From: Amanda Scholes on behalf of Planning.Responses
Sent: 10 February 2021 11:05
To: Planning Scanning
Subject: FW: Y/113/20/DOC - Land South of Ford Lane and East of North End Road, Yapton - CONDITION 11

We do not recommend discharge of condition 11 at this time. An updated maintenance manual and drainage statement have been provided to us, none of these are on the public planning portal yet.

Are you satisfied with the plans and documents that you have received for **Condition 11** of discharge of condition application Y/113/20/DOC which are set out below:

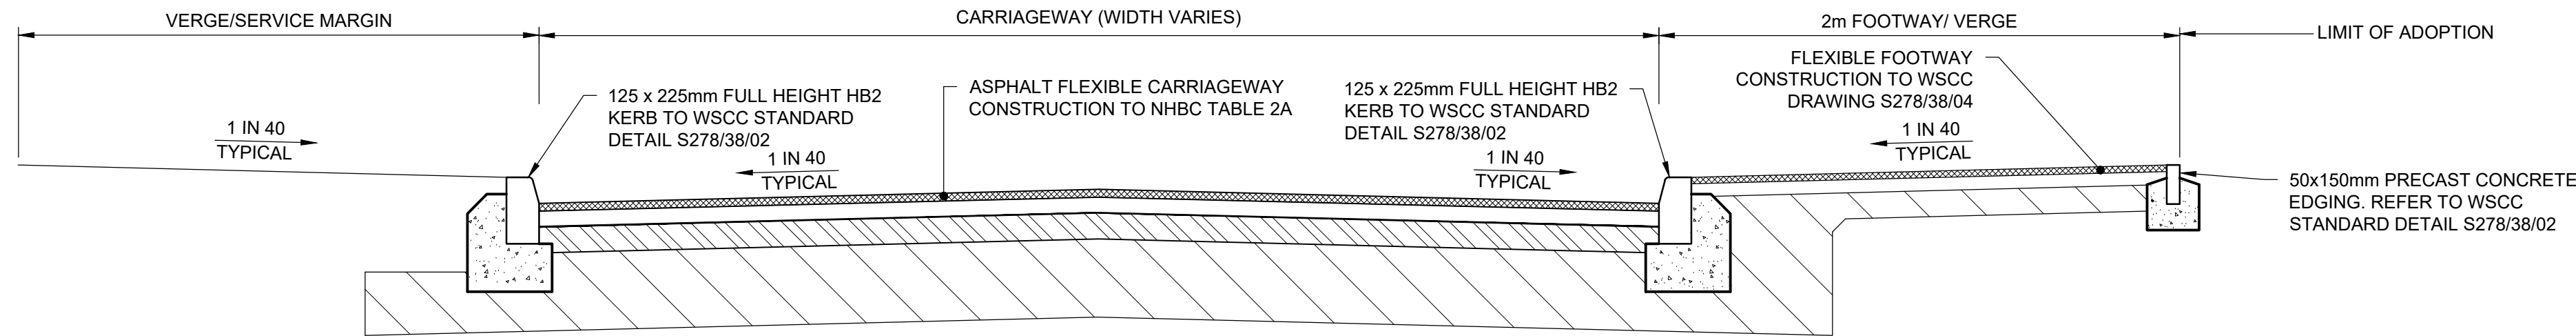
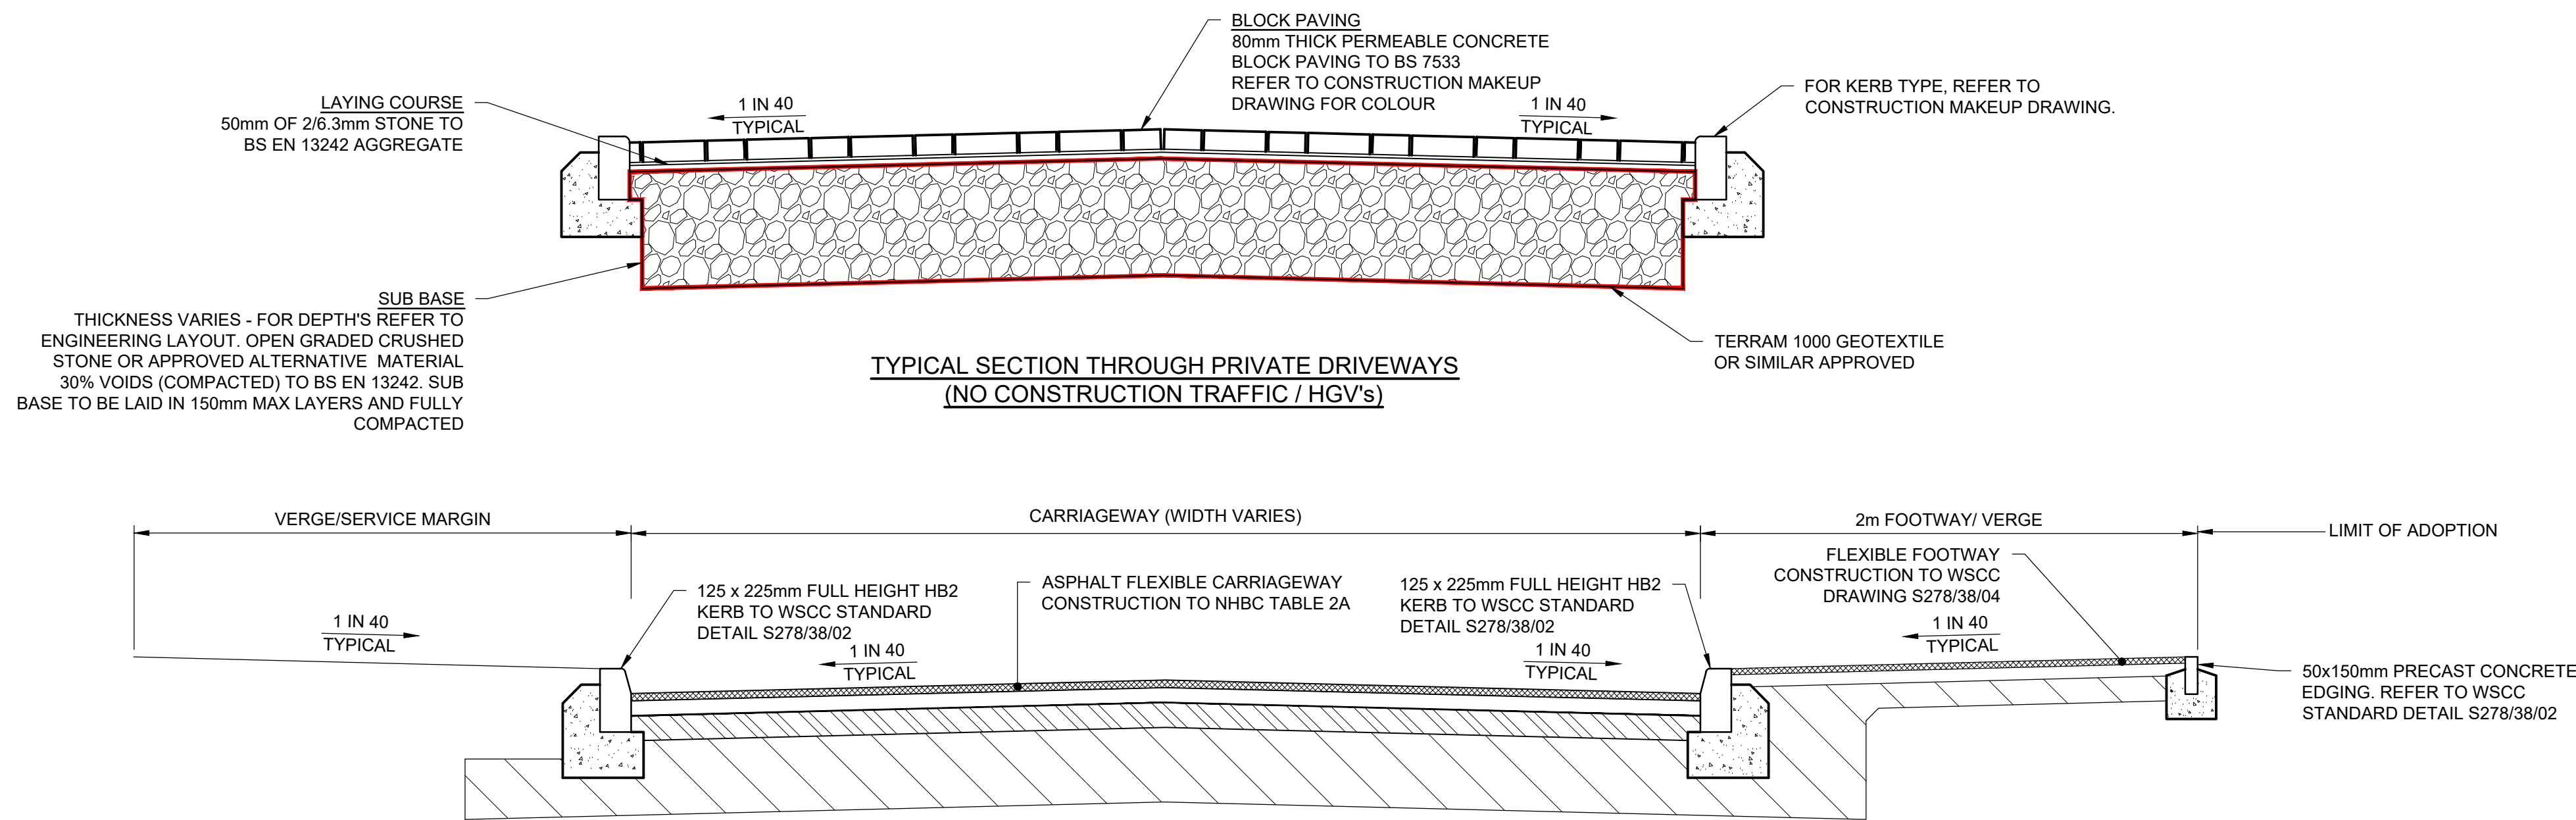
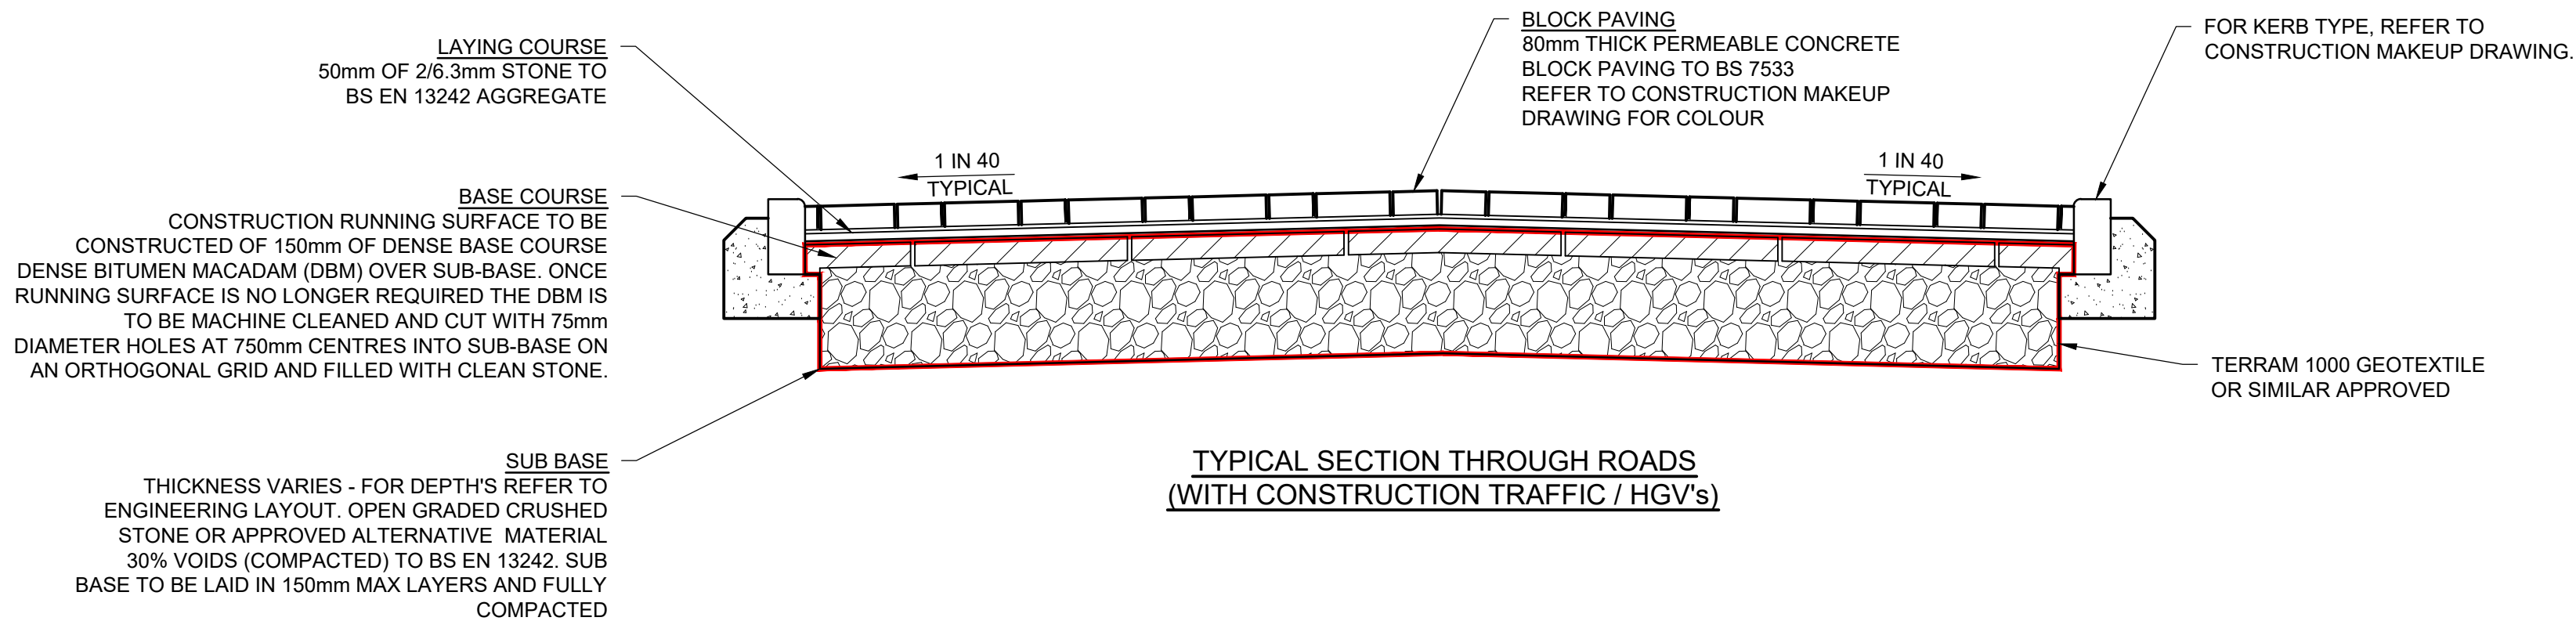
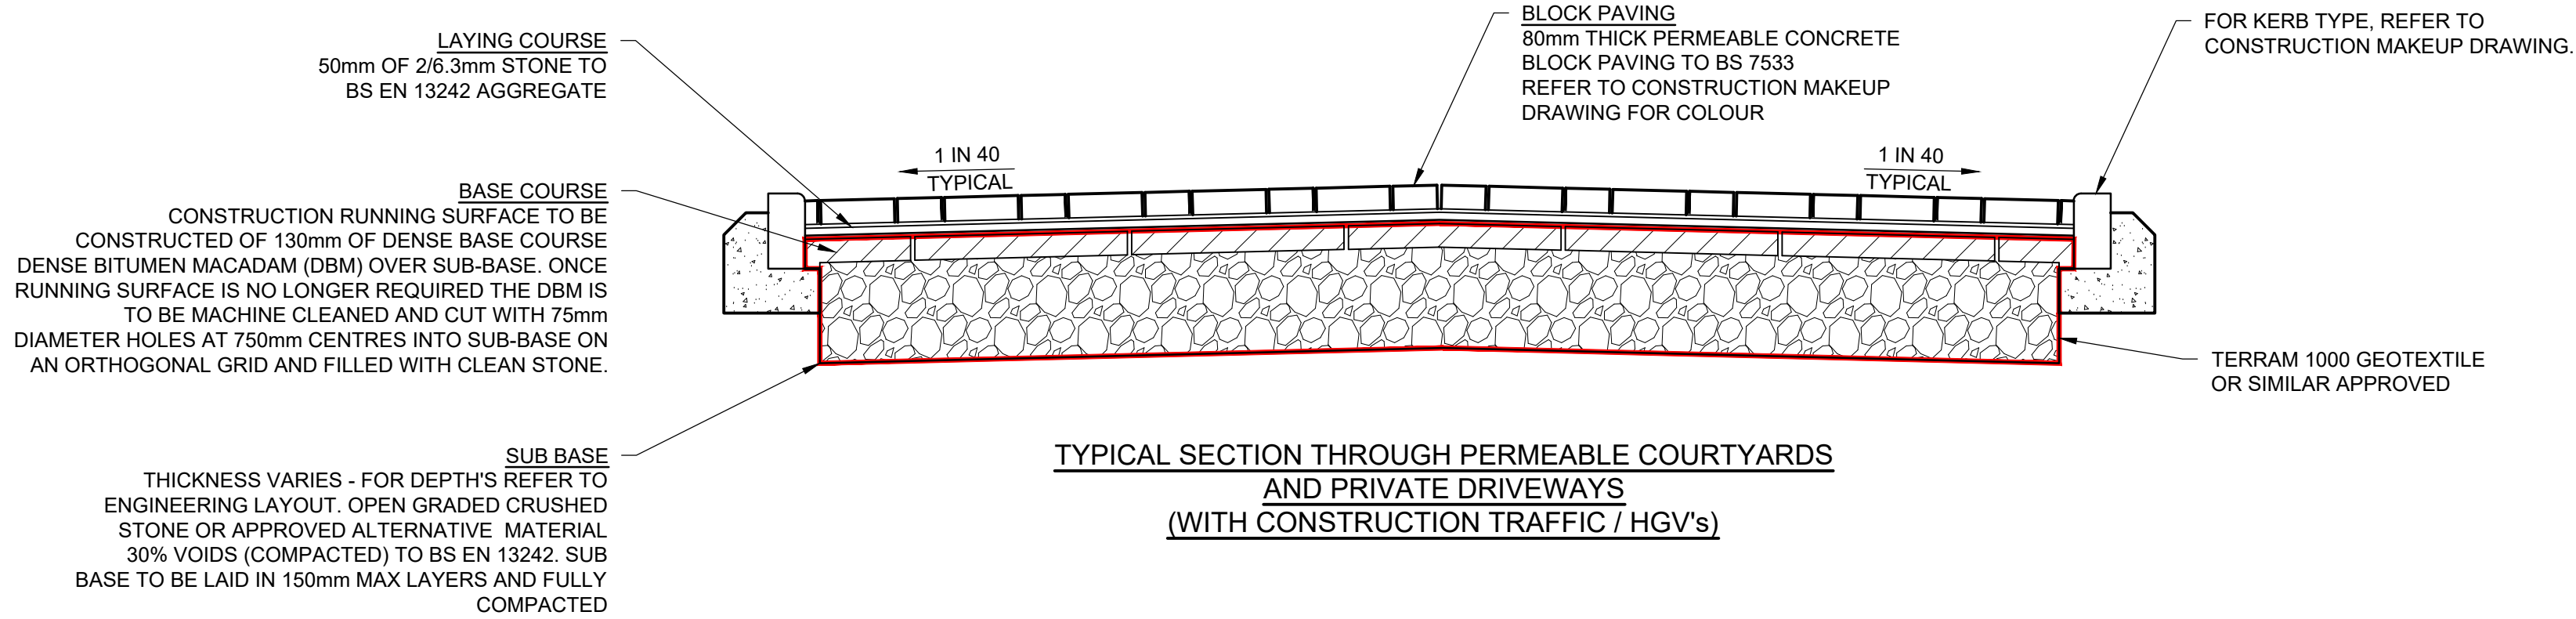
7. Why do some plots have diffuser blocks located in the drive, and some in the road? E.g. around plots 51-60 and 79-82? Surely they all need to go through to the road as you have not shown additional linkages with diffuser blocks through these service corridors.

8. Please detail invert levels of all diffuser blocks, some of the blocks which are used to cross service corridors are missing.
9. Please provide additional SBILs closer to diffuser blocks.

10. It does not appear that all rwp's are connected. Please adjust, or add not to explain.
11. Some of the roads are missing SBILs.
12. Where connections are being made to pipelines rather than direct to manholes – add note 'all connections to be made using oblique 45 degree junctions'

14. I note from the layout that some baffles are to have 100mm diameter pipes through them to link sub-base areas. Please provide a construction detail drawing.

15. Please state unit reference of hydrobrakes on plan.
16. Please provide site specific construction detail drawings of the hydrobrakes.
17. Are all catchpits to have a permafilter? Why is this being specified?
